# CITY OF ALBUQUERQUE

Re: **Bubba's 33**  
**10000 Coors ByPass NW**  
**Traffic Circulation Layout**  
Engineer's Stamp 03-19-21 (B14-D004H)

Based upon the information provided in your submittal received 03-22-2021, the above referenced plan cannot be approved for Building Permit until the following comments are addressed:

**ACCESSIBLE PARKING STALL DETAIL**

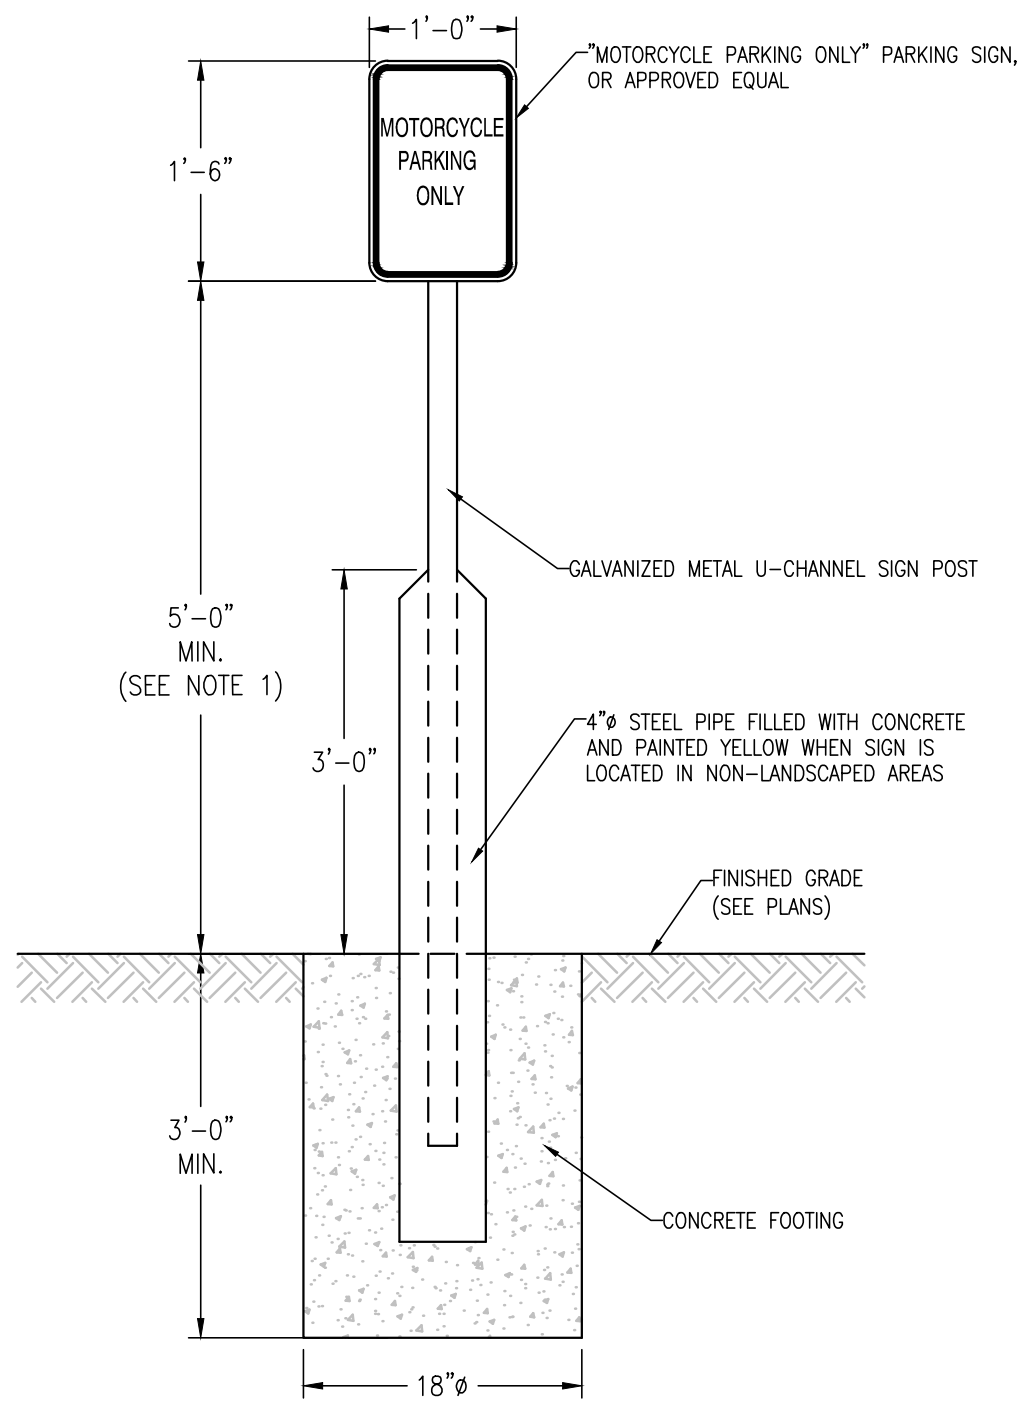
11. The ADA accessible parking sign must have the required language per 66-7-352.4C NMSA 1978 **"Violators Are Subject to a Fine and/or Towing."** Please call out detail and location of signs.

12. The ADA access aisles shall have the words **"NO PARKING"** in capital letters, each of which shall be at least one foot high and at least two inches wide, placed at the rear of the parking space so as to be close to where an adjacent vehicle's rear tire would be placed. (66-1-4.1.B NMSA 1978).

BIKE RACK DETAIL  
NOT TO SCALE

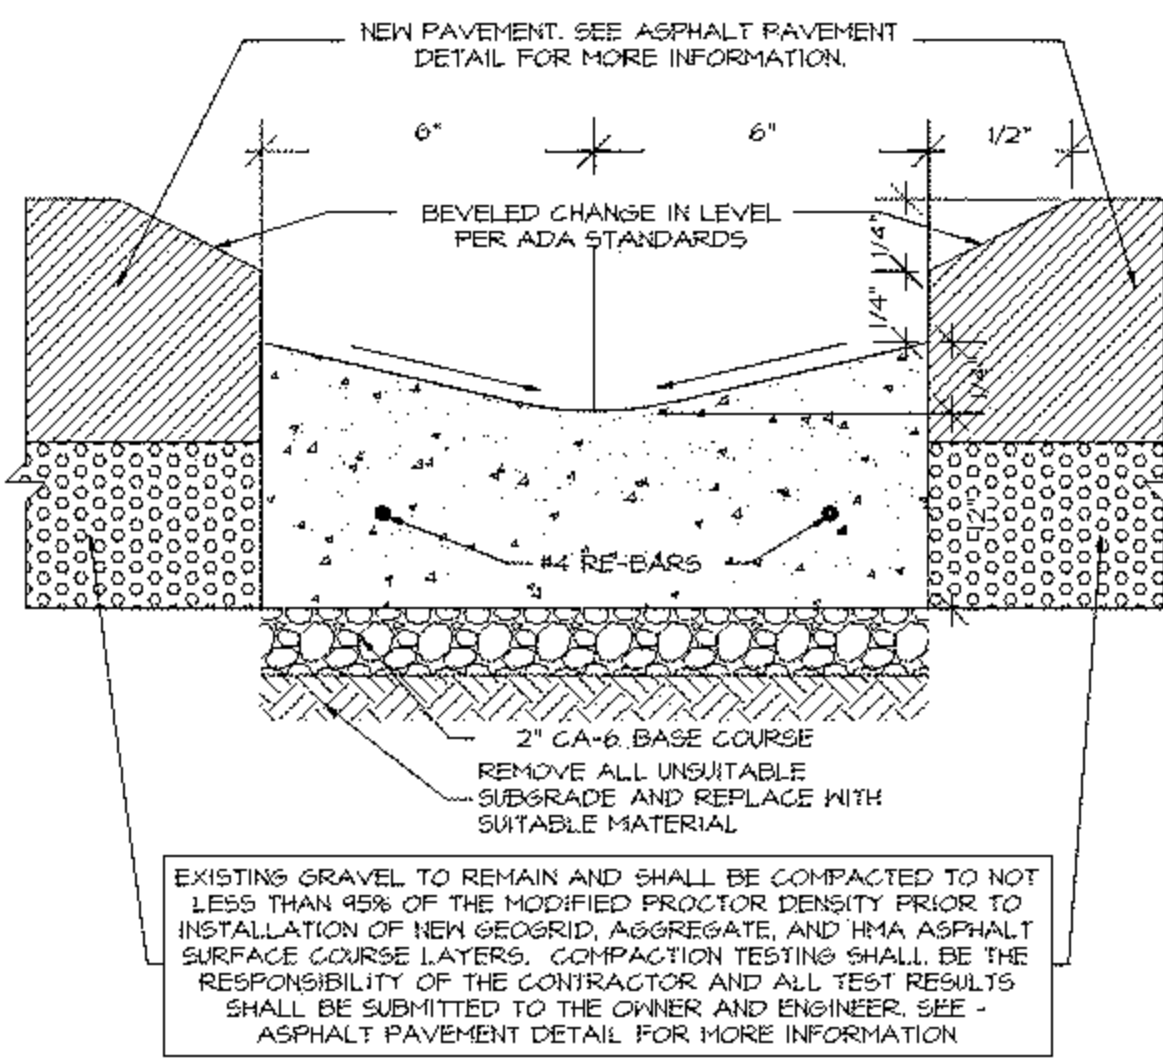
14. All bicycle racks shall be designed according to the following guidelines (Reflect bike notes onto site plan and/or detail sheets):
  - a. The rack shall be a minimum 30 inches tall and 18 inches wide.

- b. The bicycle frame shall be supported horizontally at two or more places. Comb/toaster racks are not allowed.
  - c. The rack shall be designed to support the bicycle in an upright position. See the IDO for additional information.

- d. The rack allows varying bicycle frame sizes and styles to be attached.
  - e. The user is not required to lift the bicycle onto the bicycle rack.

- f. Each bicycle parking space is accessible without moving another bicycle.
15. Bicycle racks shall be sturdy and anchored to a concrete pad.
16. A 1-foot clear zone around the bicycle parking stall shall be provided.

17. Bicycle parking spaces shall be at least 6 feet long and 2 feet wide.
18. List radii for all curves shown; for passenger vehicles. Radius for delivery trucks, **fire trucks**, etc. is 25 ft. or larger. **Provide Fire Dept. approval for the proposed route around you proposed development site.**
